Your Ref: 100654967-001  
Our Ref: 23/03516/FULL

**Application No:** 23/03516/FULL  
**Proposal:** Extension to shop front  
**Address:** 4 Bell Street St Andrews Fife KY16 9UX

| ESSEL SECURITIES LTD | | 4 BELL STREET ST ANDREWS | | DOOR AND WINDOW AS PROPOSED | | 1-20 PROJECT NO S1503 | | 10/23 DRAWING NO 004 | | A3 REVISION - | | | | |

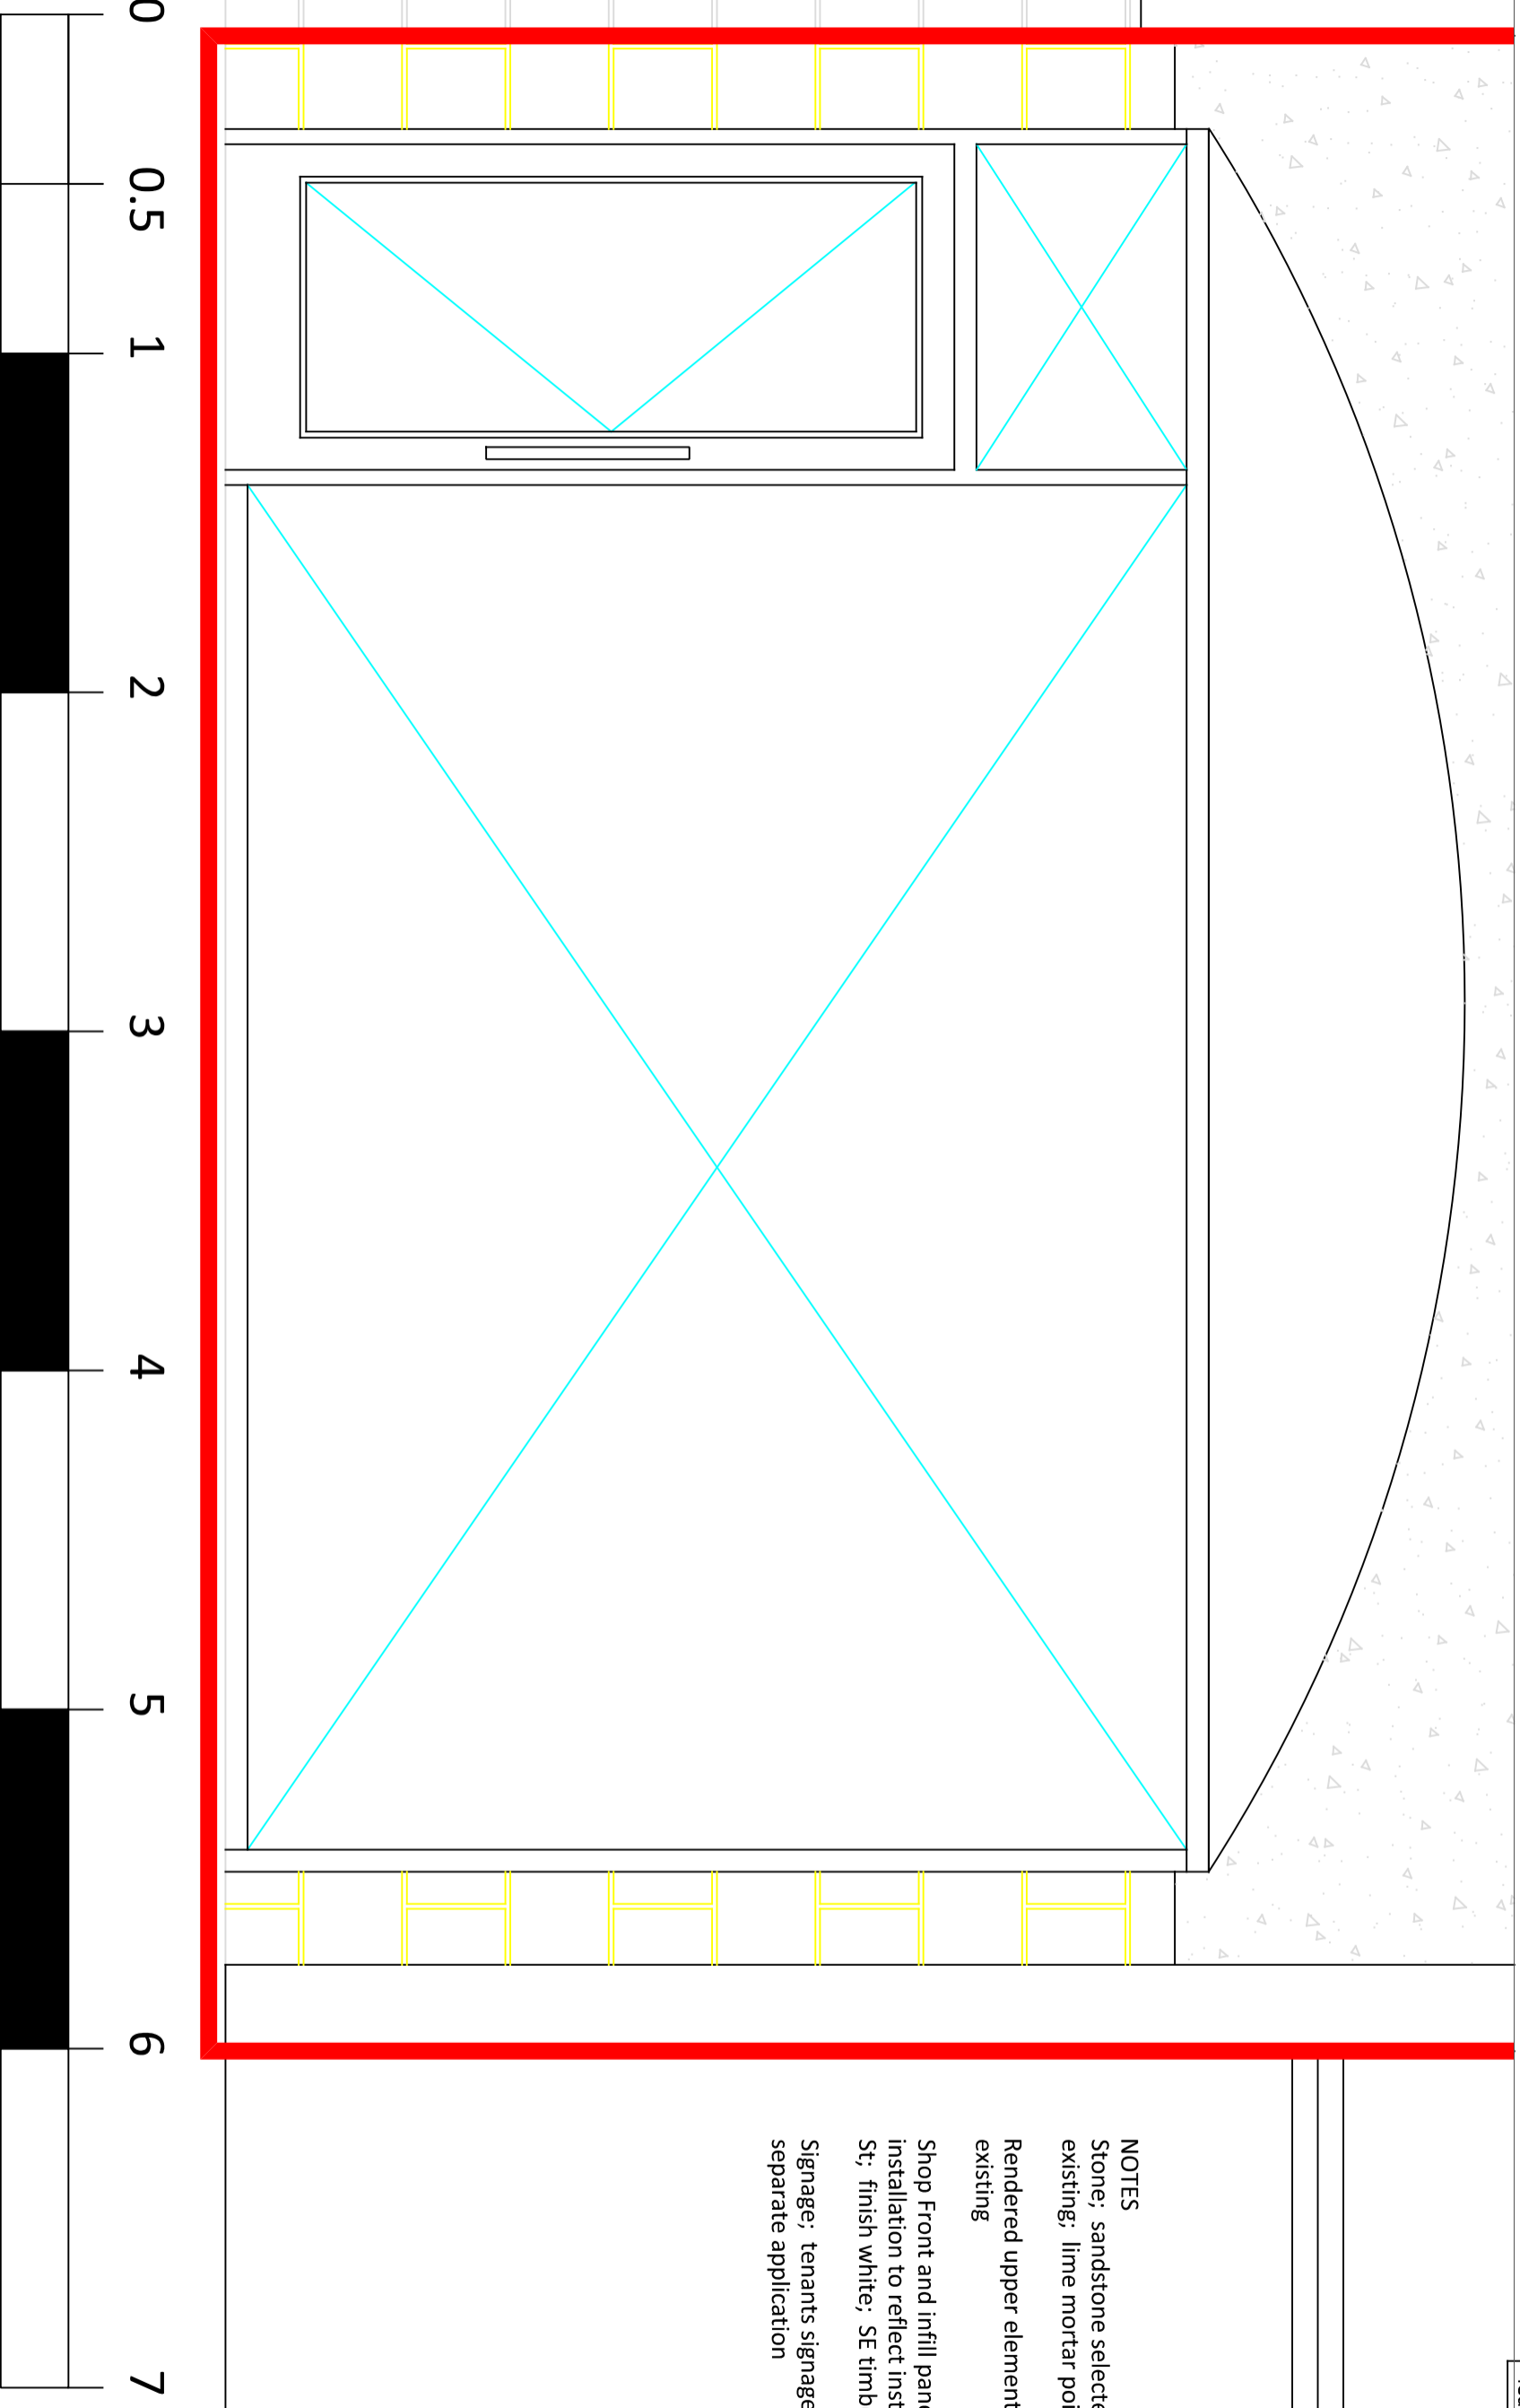
1. You have not submitted proposed door elevations at a scale of 1:20. If applicable please submit proposed astragal details at a scale of 1:1.
2. You have not submitted existing and proposed window elevations at a scale of 1:20. If applicable please submit existing and proposed astragal details at a scale of 1:1.
3. In order to fully assess your application, please submit elevations with the proposed signage, along with an accurate scale bar.
4. You have not completed the Low Carbon checklist. From the 1st April 2019, this needs to be fully completed in order to validate your planning application in accordance with our Local Development Plan - FIFEplan. The checklist can be found on our website at <https://www.fife.gov.uk/kb/docs/articles/planning-and-building2/planning/development-plan-and-planning-guidance/planning-guidance-under-Adopted-Supplementary-Guidance-Low-Carbon-Fife>.
